Recommendation Report for Outline Consent

REF NO: F/7/15/OUT

LOCATION: Land south of Burndell Road
Yapton

PROPOSAL: Outline application for residential development comprising 45 dwellings. Formation of access onto Burndell Road (Resubmission following F/9/14/PL) - This application also lies within the parish of Yapton. This application is a Departure from the Development Plan.

Proposed access and highway improvements plan (Stiwell Partnership)

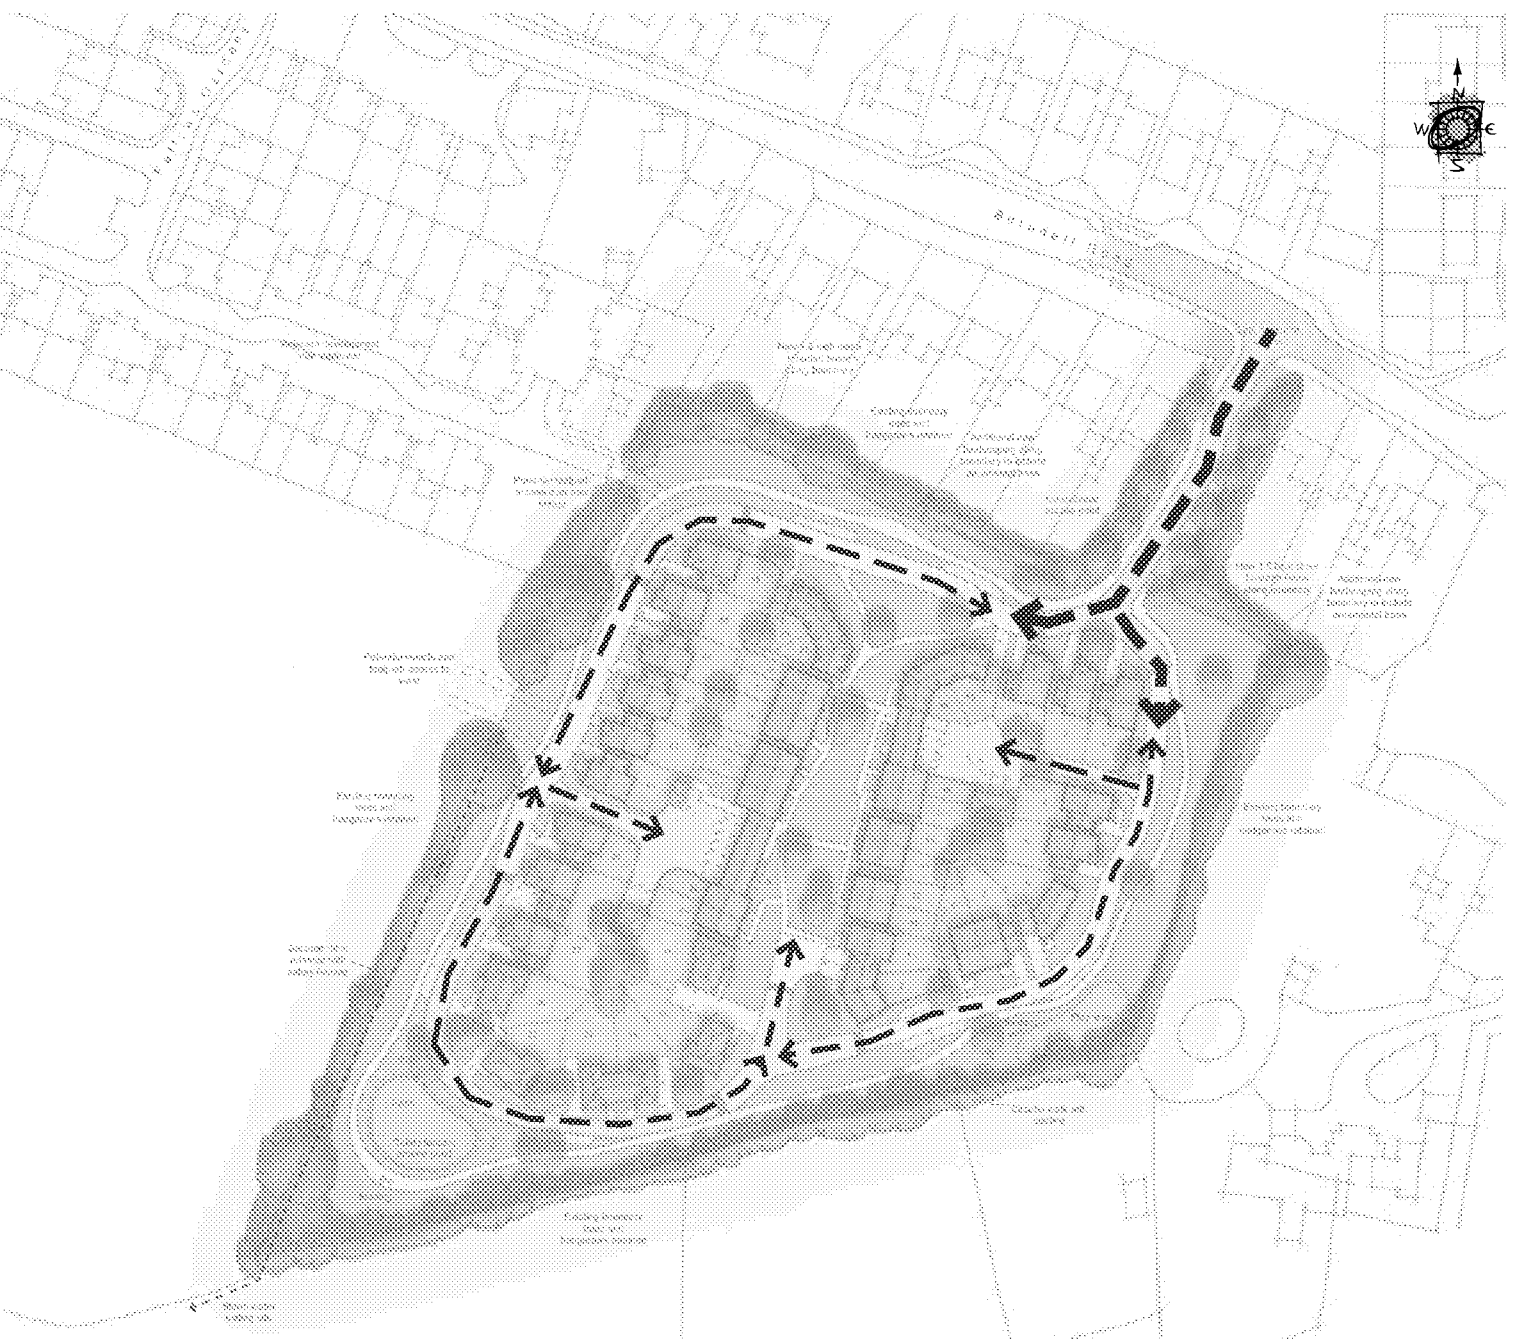
The applicant proposes a simple 'T' junction arrangement onto Burndell Road via a formalised estate road entrance with kerb radii, provision of a new footway on south side of road, alterations to an existing footway on the northern side of the Burndell Road and visibility splays is appropriate to the speed of traffic on Burndell Road.

To form the access, part of Burndell Road will be re-aligned to bring the give-way line for the new road forward to obtain the visibility splays. Parts of existing lay-bys either side of Burndell Road will be amended to provide for an uncontrolled crossing point for pedestrians.

Figure 2 - Proposed Improvements – Foul system

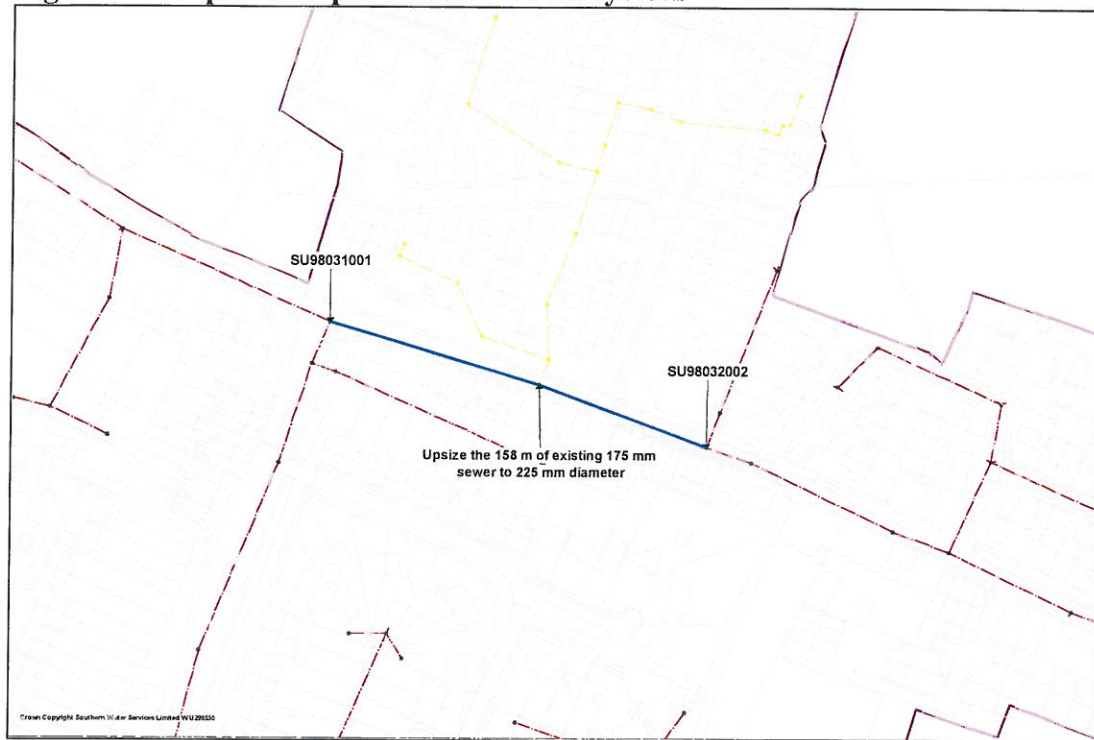
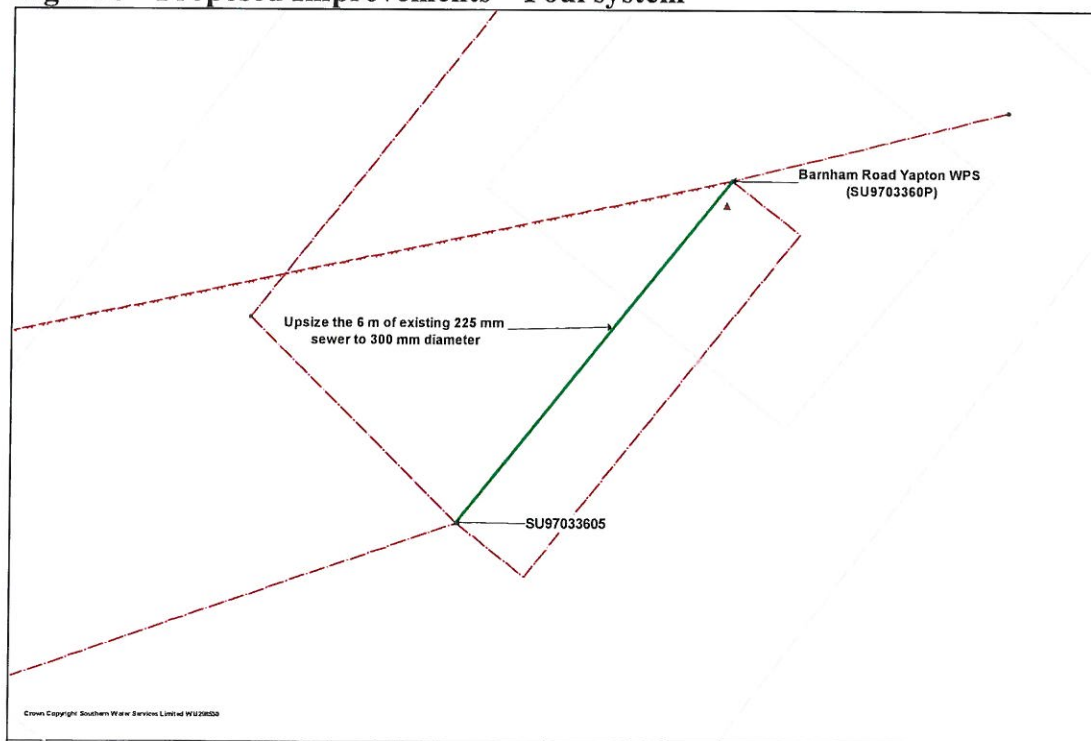
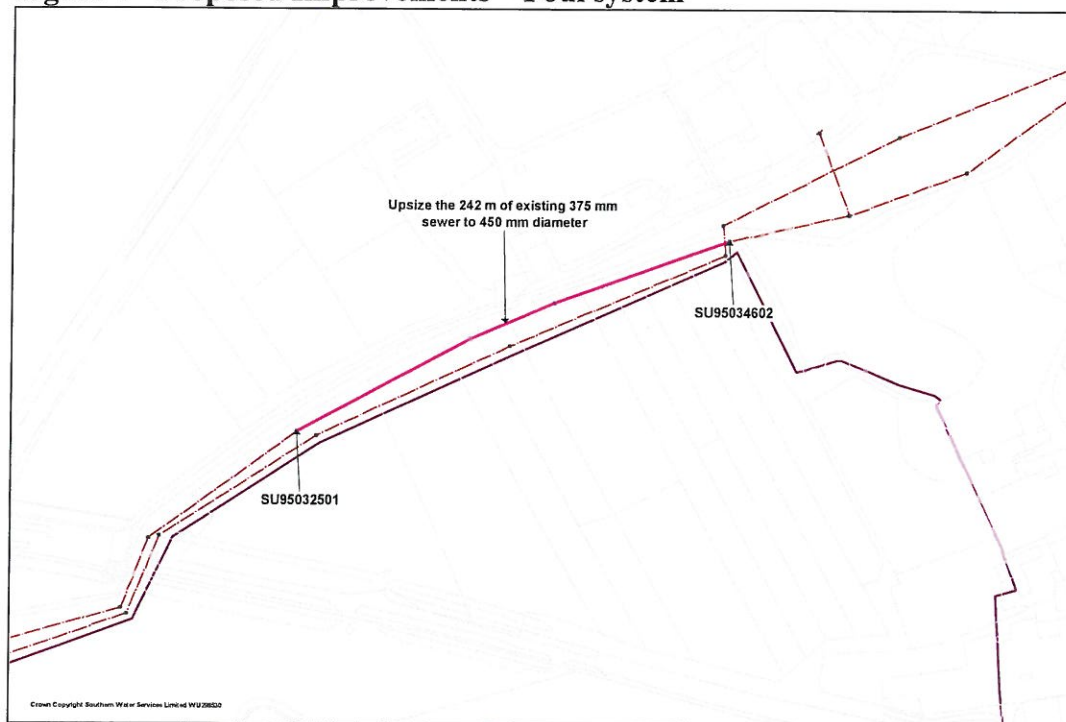
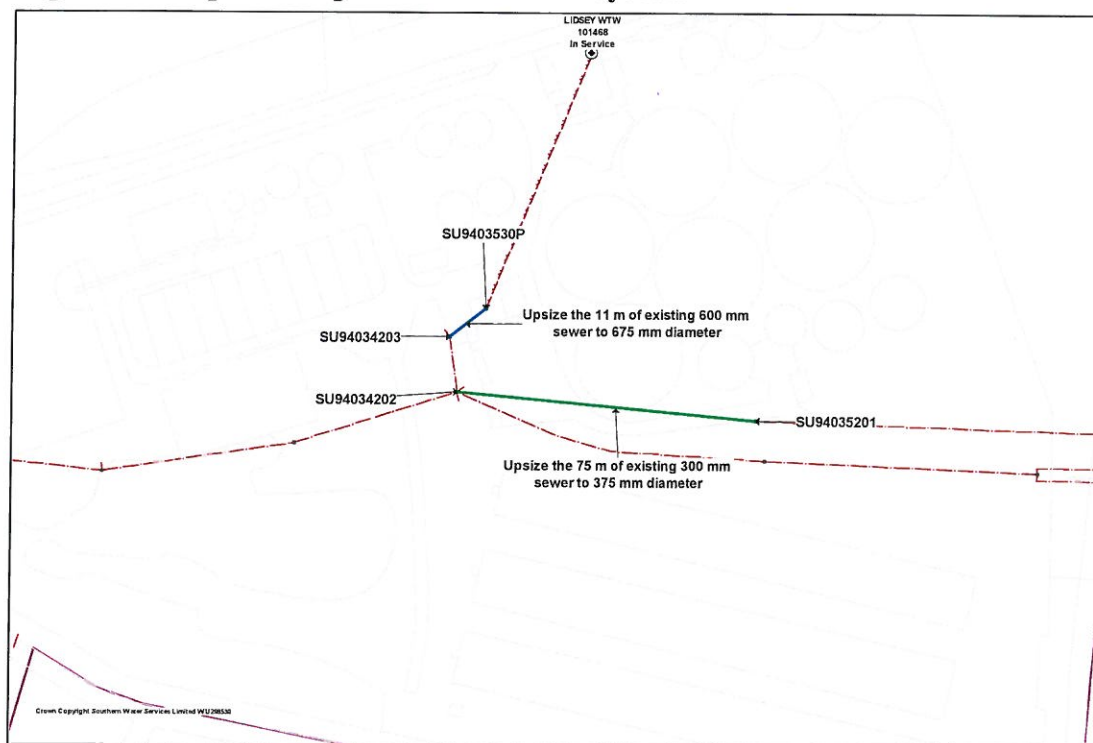
The initial investigations indicate that there is inadequate capacity in the local network to provide foul sewage disposal to service the proposed development. The proposed development would increase the flows to the public sewage system and existing properties and land would be subject to a greater risk flooding as a result. Additionally off-site sewers or improvement to existing sewers will be required to provide a sufficient capacity to service the development.

Should the application receive planning approval, the following condition to be attached to the consent: "Construction of the development shall not commence until details of the proposed means of foul and surface water sewerage disposal have been submitted to, and approved in writing by the LPA in consultation with Southern Water.
